Our Ref: RM8 IDA16/71

**Re: Residential subdivision, Lot 1 DP 1097743, Pacific Highway,
Moonee Beach, Coffs Harbour LGA (SSD 7198, *formally* MP09_0067)
provision of additional information on buffers to aquatic habitats**

I acknowledge receipt of your email dated 19 October 2016 and the attachment Drawing Number 1277-DR1 Issue G. Moonee Parklands, Proposed Moonee Urban Subdivision Moonee Beach Lot 1 DP 1097743, Proposed Subdivision Lot Layout (copy attached).

Attachment A
Revised Subdivision Plans – Civiltech

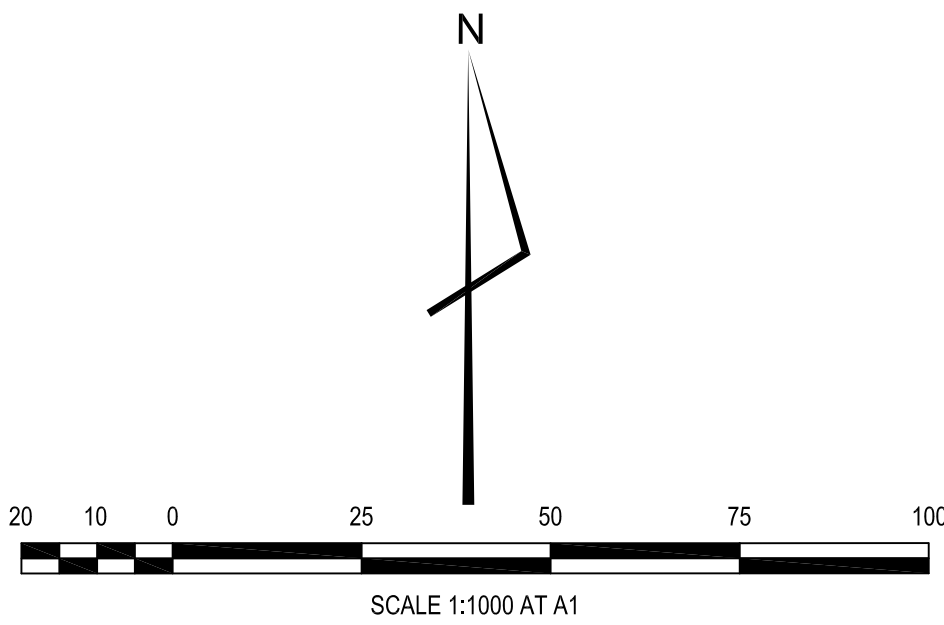
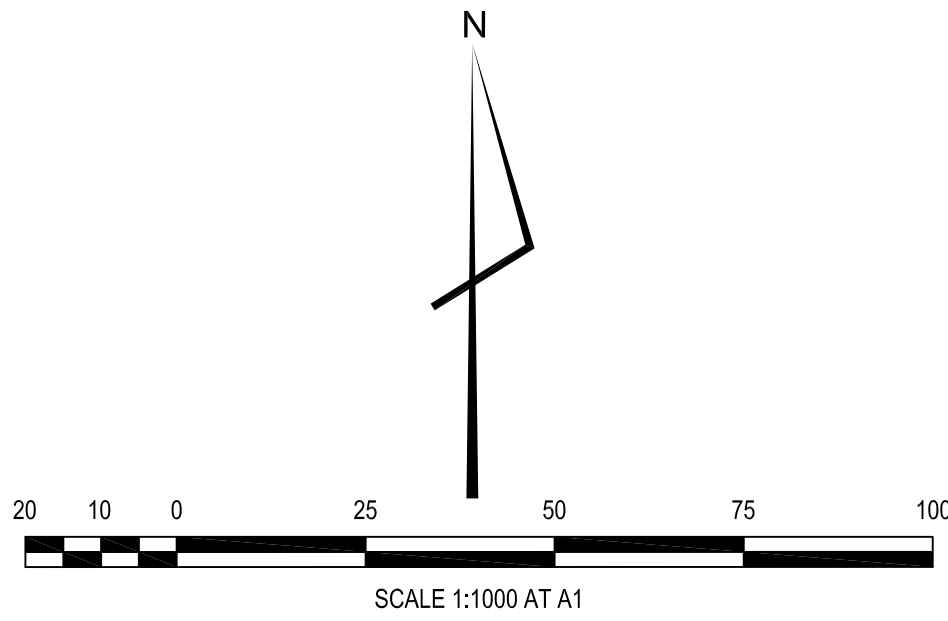
This plan depicts a line representing the outer edge of the extent of intertidal habitat that requires a habitat buffer. This line is appropriately beyond the mean high water mark and at or just slightly above the highest astronomic tide. The plan therefore, enables a more accurate assessment of the habitat buffer to the key fish habitat areas which include saltmarsh, mangrove and seagrass within Moonee Creek which is a Habitat Protection Zone within the Solitary Island Marine Park.

The Plan clearly shows that at its narrowest point the buffer to intertidal habitats in Moonee Creek from built urban infrastructure, specifically the proposed coastal walk, will be approximately 25 metres. In other areas the buffer between the coastal walk and intertidal habitats will exceed 60 metres. In almost all areas the buffer to the ring road and residential development exceeds 50 metres. There is one very small point where the distance is reduced to 46 metres. It appears that functions such as the asset protection zone and mosquito buffers would generally occupy the area occupied by the proposed coastal walk and the ring road. The integrity of the vegetated habitat buffer would, therefore, be somewhat maintained against weed encroachment and other disturbance despite its limited width.

The mapping that was requested by DPI Fisheries shows that the buffer zone that has been developed is narrow. Particularly when considering the important habitats adjacent to it, specifically a Habitat Protection Zone within the Solitary Islands Marine Park, one of the largest seagrass beds in Moonee Creek and an intertidal zone that includes saltmarsh habitats which are listed as an endangered ecological community. It is noted, however, that the proponent proposes that the buffer zone will be dedicated to Coffs Harbour City Council and that a regime of endemic native rehabilitation is proposed consistent with a Vegetation Management Plan.

DPI Fisheries is satisfied that the proposed buffer is generally consistent with the Department's policy and guidelines for fish habitat conservation and management contingent upon any approval for this development requiring; rehabilitation and sound management of the buffer zone undertaken consistent with best practice techniques, and dedication of the buffer zone to Coffs Harbour City Council.
